Kirklees Council - Public Health Consultation

Whilst a Rapid HIA has been submitted -some of the statements are vague and lacking detail. Where supplementary documents indicating where the relevant information could be found was listed, it would have been helpful to identify page numbers for ease of finding. Bearing in mind there were over 20 supporting documents-it has not been feasible to read them all. Therefore, this PH response has been prepared based on a read of the DAS/planning statement documents.

Appendix C – Development Proposals

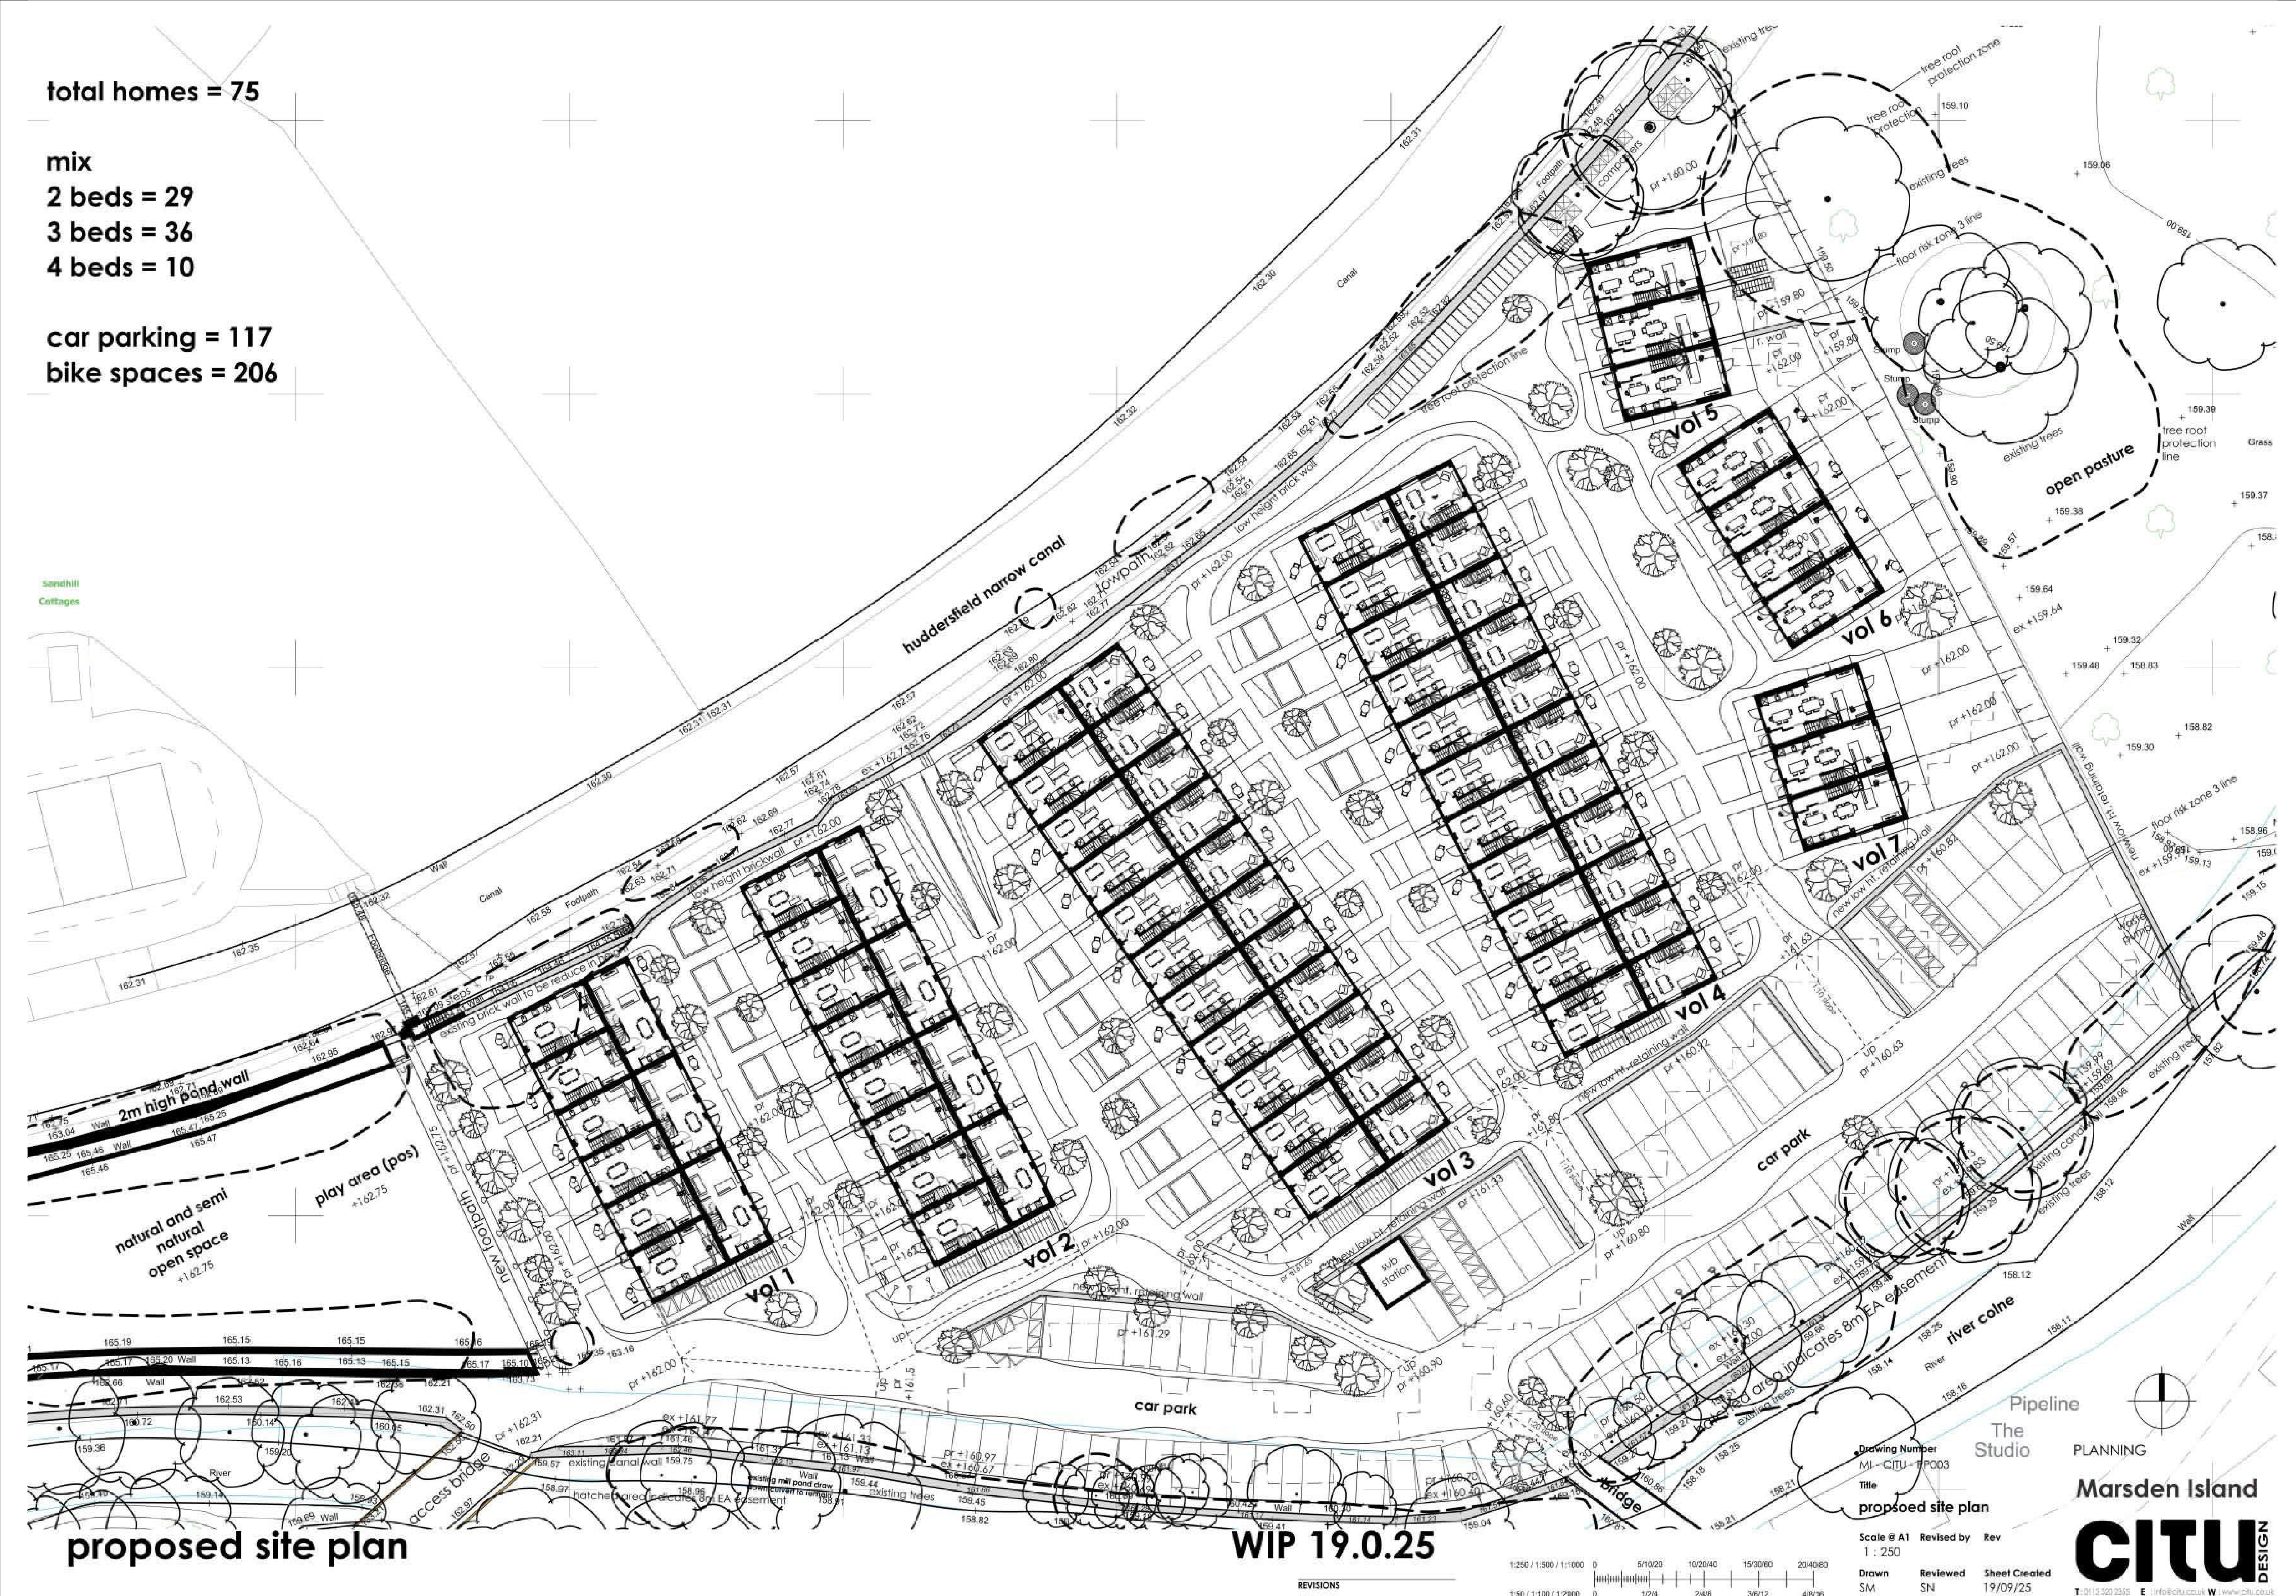
The site plan does show a children's play space; however, PH is unsure whether this is part of the proposed development or an existing provision? Has a pocket park/s been considered? PH unable to identify anything in the DAS relating to this.

The play space area identified on the landscape plan is part of the development site. Detailed proposals for this are being developed and a separate detail will be submitted. All external areas will also serve as shared amenity space and we are looking at options to include natural play space provisions, which may form a pocket park within the site.
